**Brookvale Community Health Centre (SSD 6980)  
Notice of Exhibition**

TfNSW provides the following key comments on the above development application and the details of key comments are provided in **TAB A**.

## **TAB A – Detailed Comments on the Development Application**

10

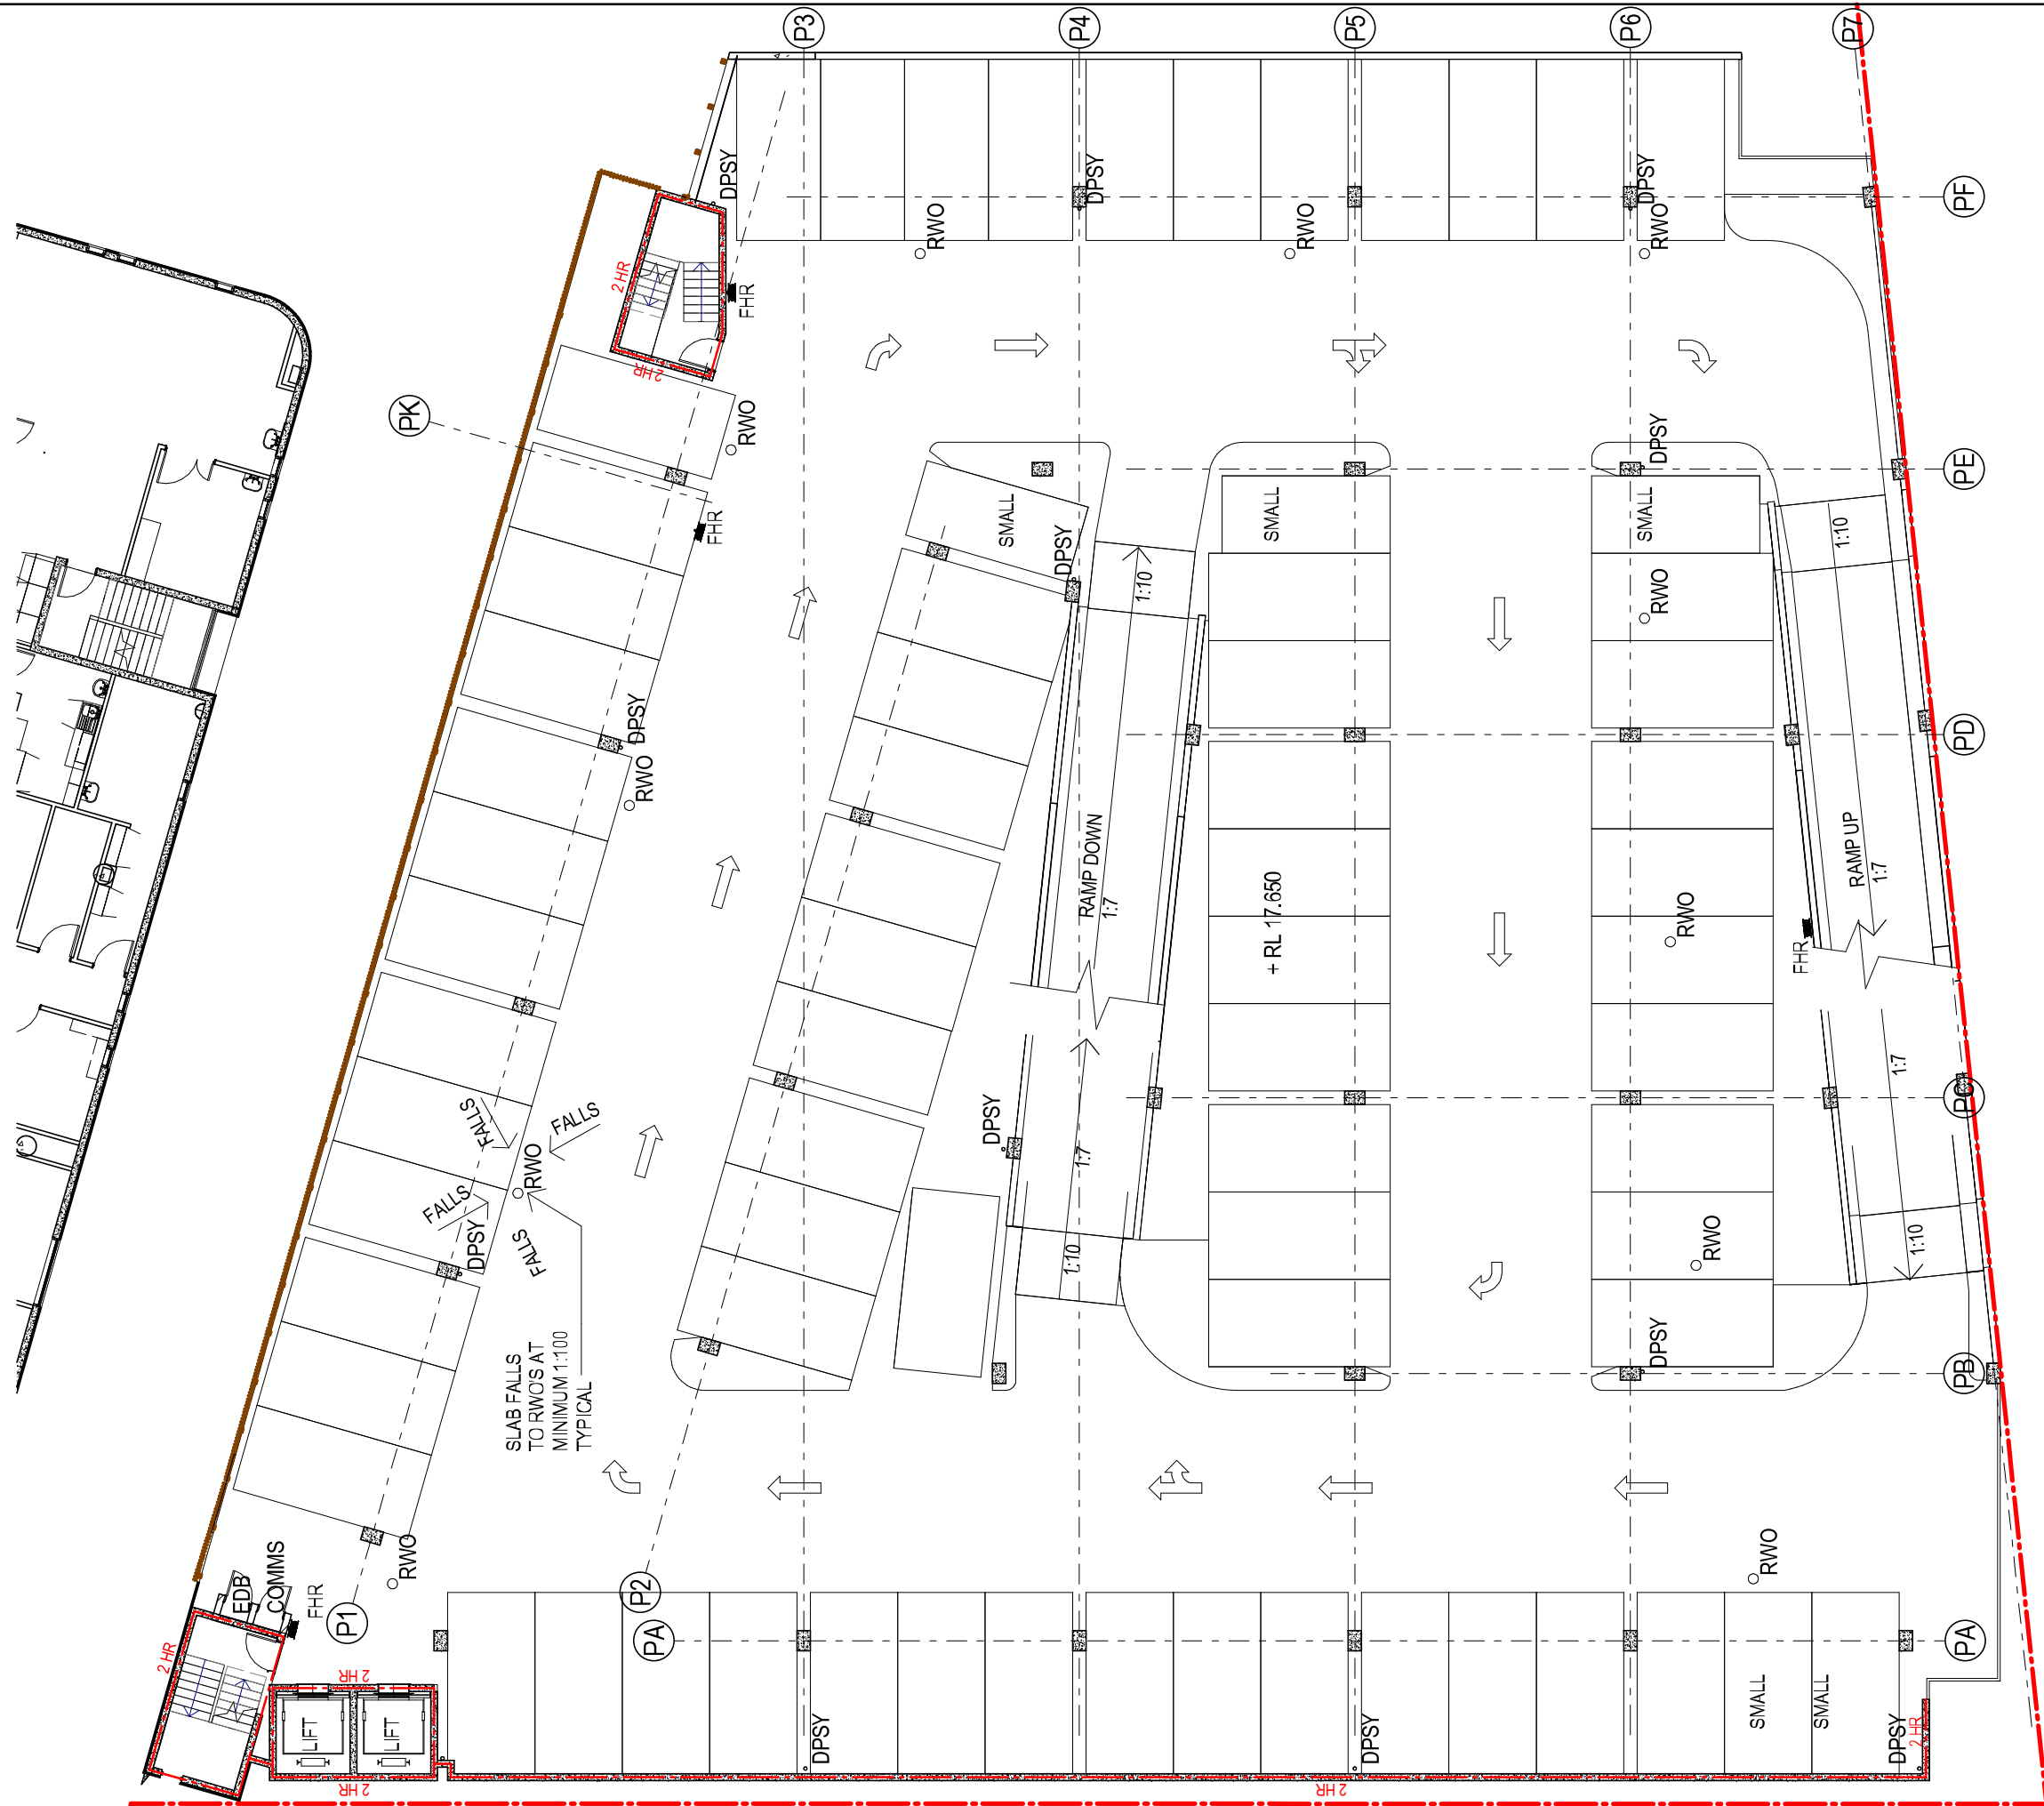
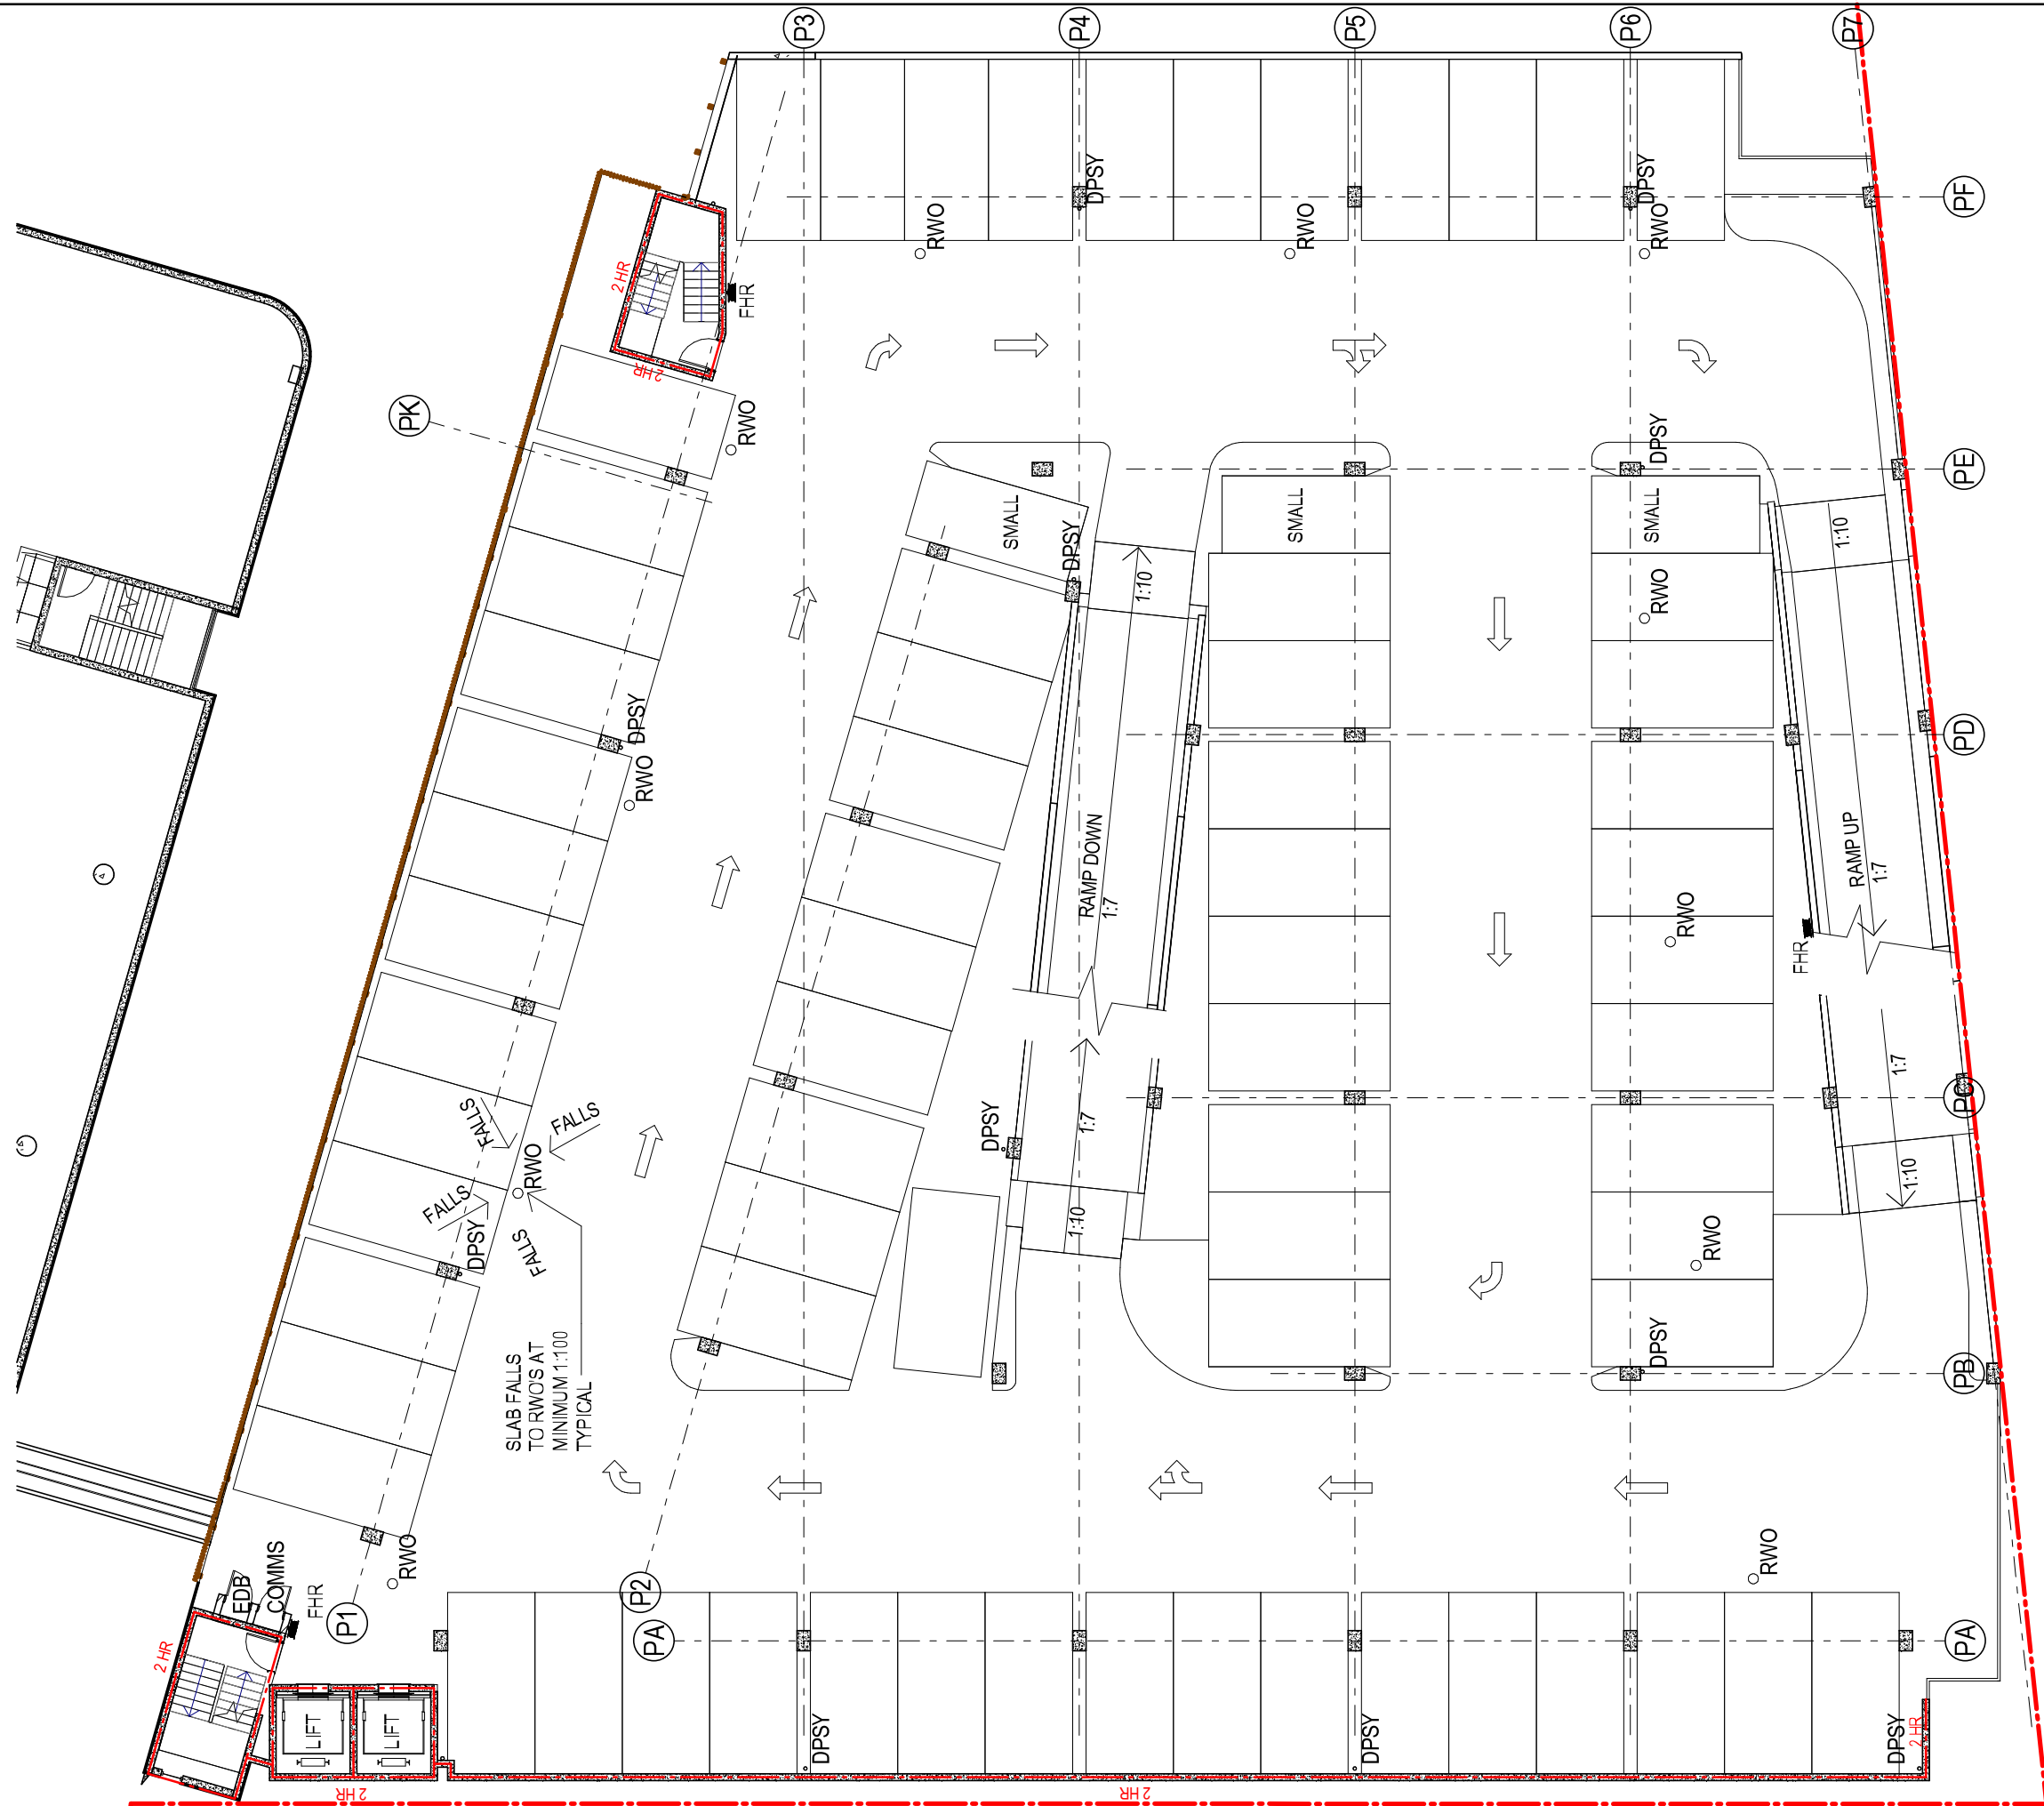
Any queuing from the BCHC access on Pittwater Road in the bus lane would have the potential to impact on travel time of bus services. It is likely that most of the commuter parking spaces would be fully occupied early in the morning. Vehicles looking for parking will enter the car park without the knowledge of unavailability of parking spaces. These unnecessary additional movements on the bus lane will cause disruptions to bus services.

TfNSW requests that the applicant consider and implement feasible measures to prevent the potential queuing of cars from the BCHC access on Pittwater Road into the bus lane. As an example, an electronic sign could be installed at the Pittwater Road car park entrance showing the real time information in relation to number of parking spaces that are free for short term parking and commuter parking.
